WELWYN HATFIELD COUNCIL – DEVELOPMENT CONTROL
DELEGATED REPORT

APPLICATION No:	S6/2010/0094/LB
------------------------	------------------------

‘Replacement of corrugated asbestos cement roofing with lead sheet incorporating rooflights removal of redundant internal walls and raising level of part of floor. insertion of new french doors and sliding-folding doors into external walls.’

DRWG No 797.06

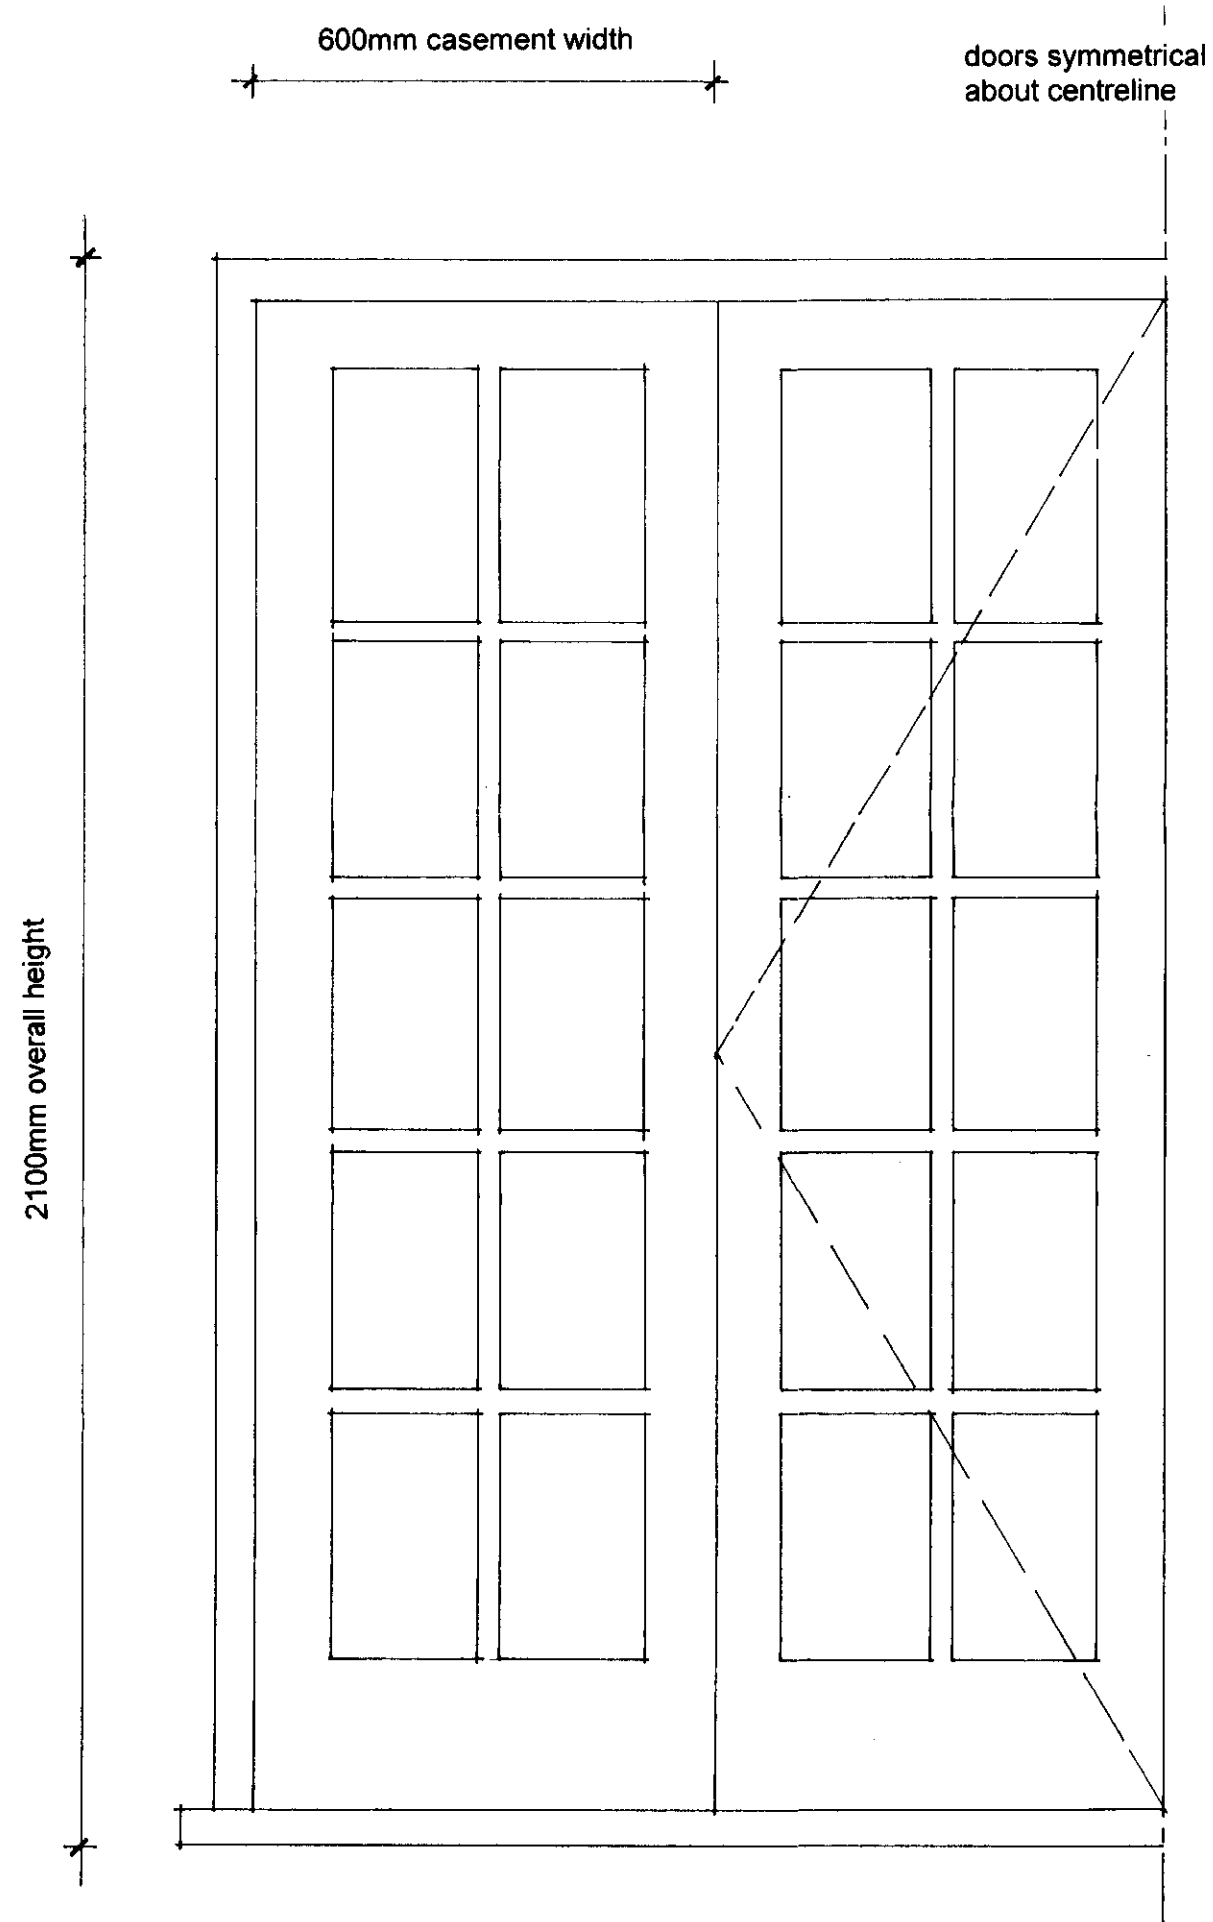
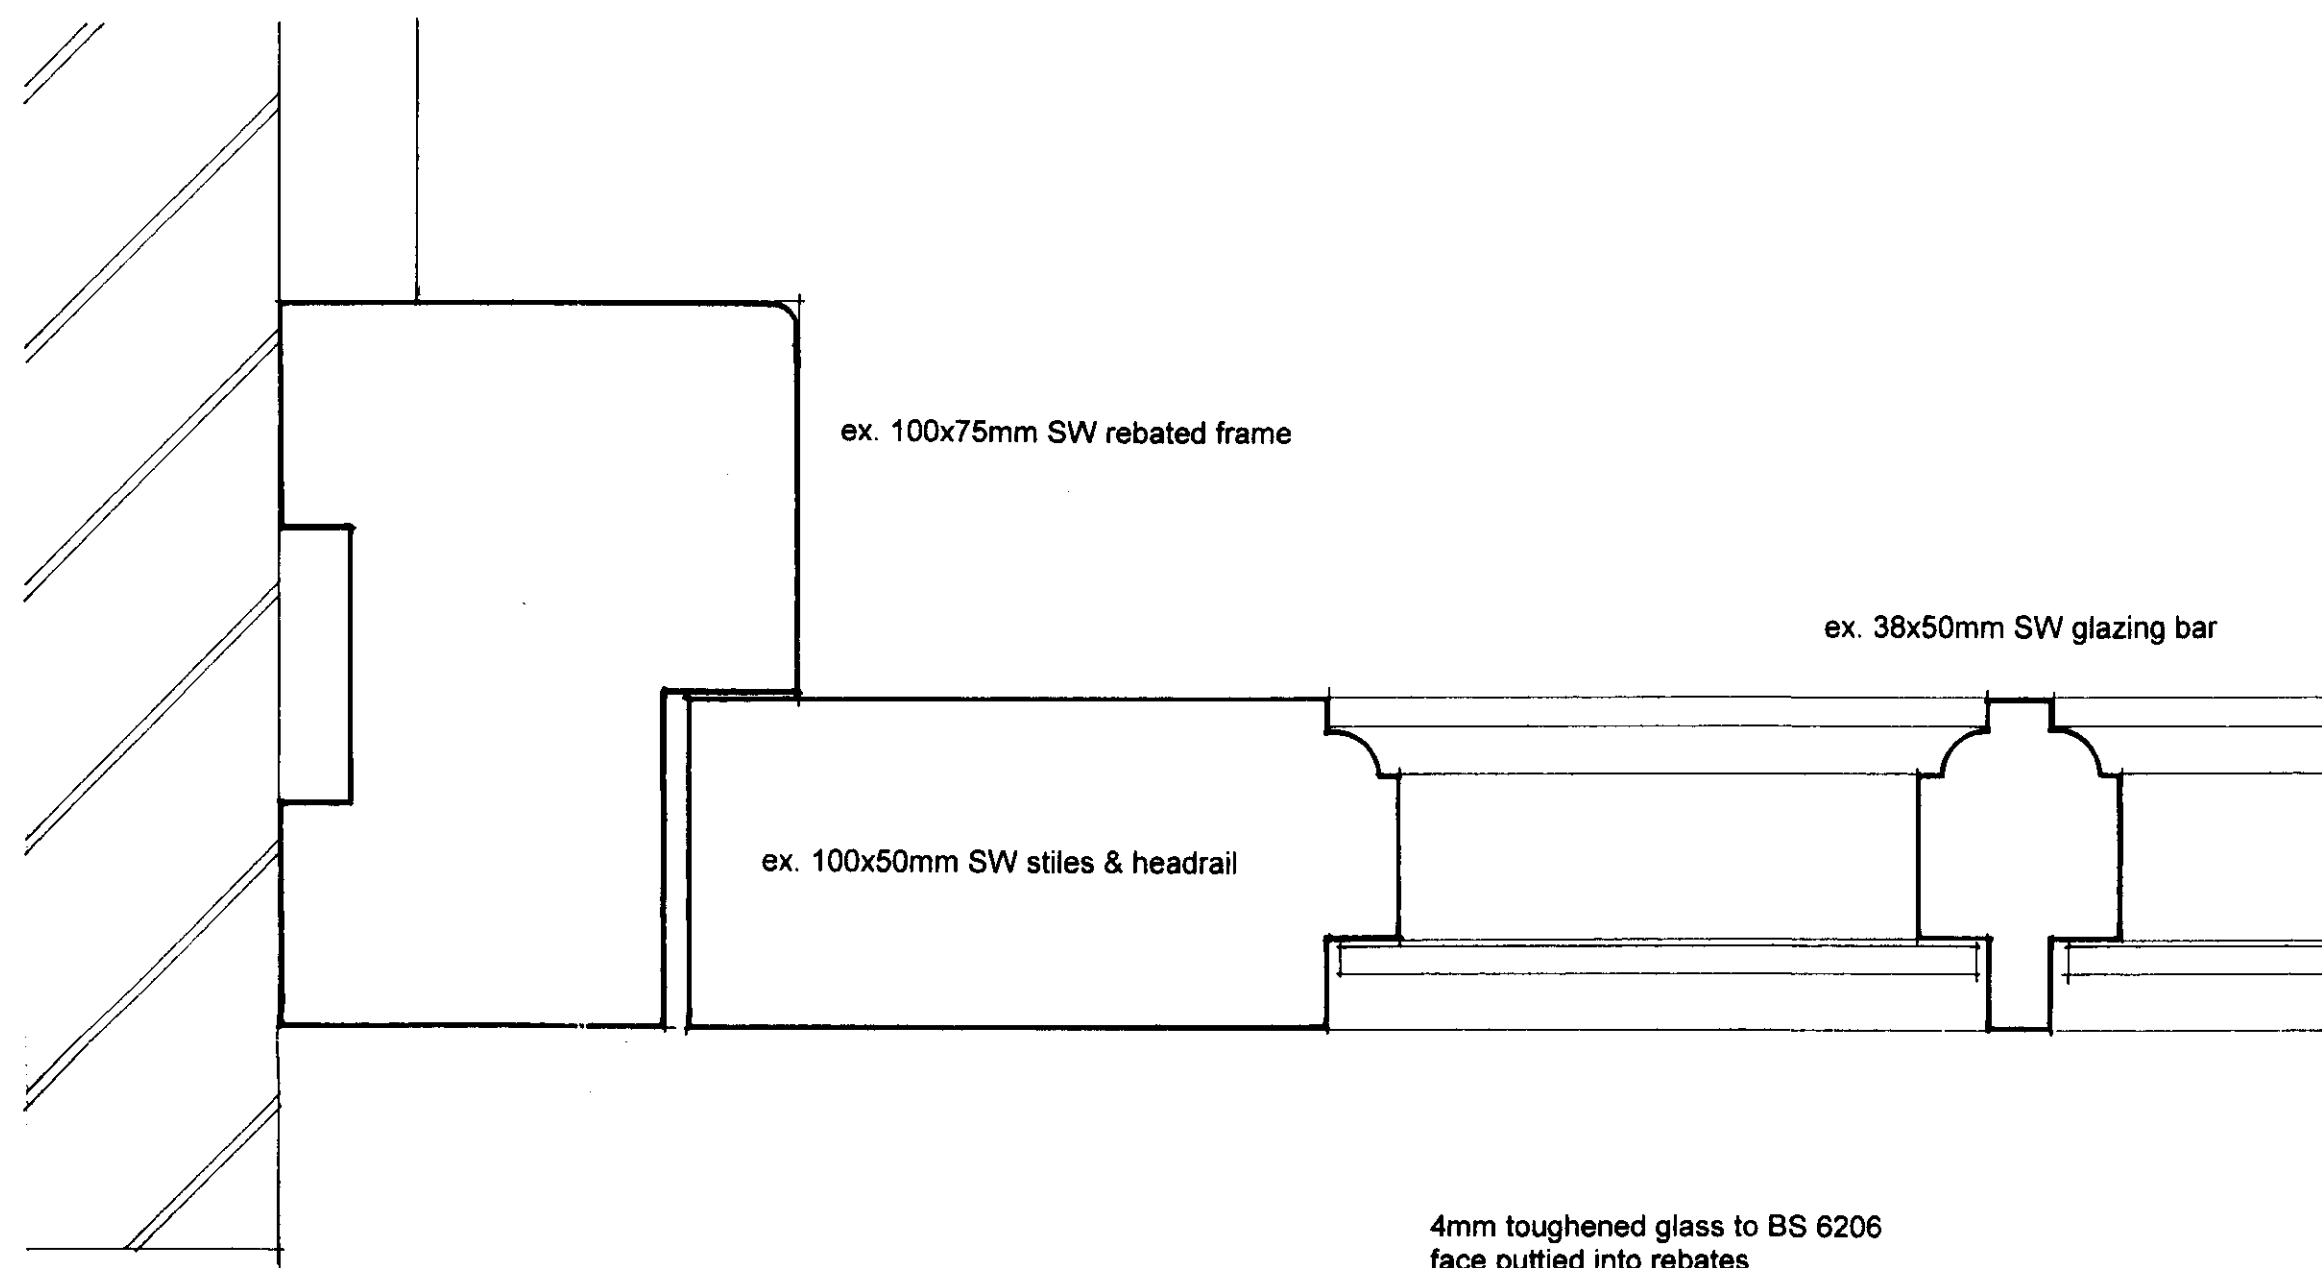
- 2.) The removal of these walls is not considered to be an issue, as this structure is a later addition to the main house.
- 3.) The increase in floor height is again not considered to be an issue, as this area of the house is not considered to be original and would have no impact on the external appearance of the building.
The proposed new French doors and new folding sliding doors are also located in this new part of the building and although they would have an impact on the external appearance, they are both located in a more discrete part of the site and the folding doors slightly below existing ground level. Subject to the materials being of a high quality and this would require the framing to be in wood, and with a painted finish to match the main doors of the house, this would be acceptable. This can be subject to a planning condition.

4. The materials and mouldings for the proposed French doors as shown on approved drawings 797.04 & 797.06 are to used in the approved development. Any variation to these details and materials are to be approved in writing with the local planning authority.
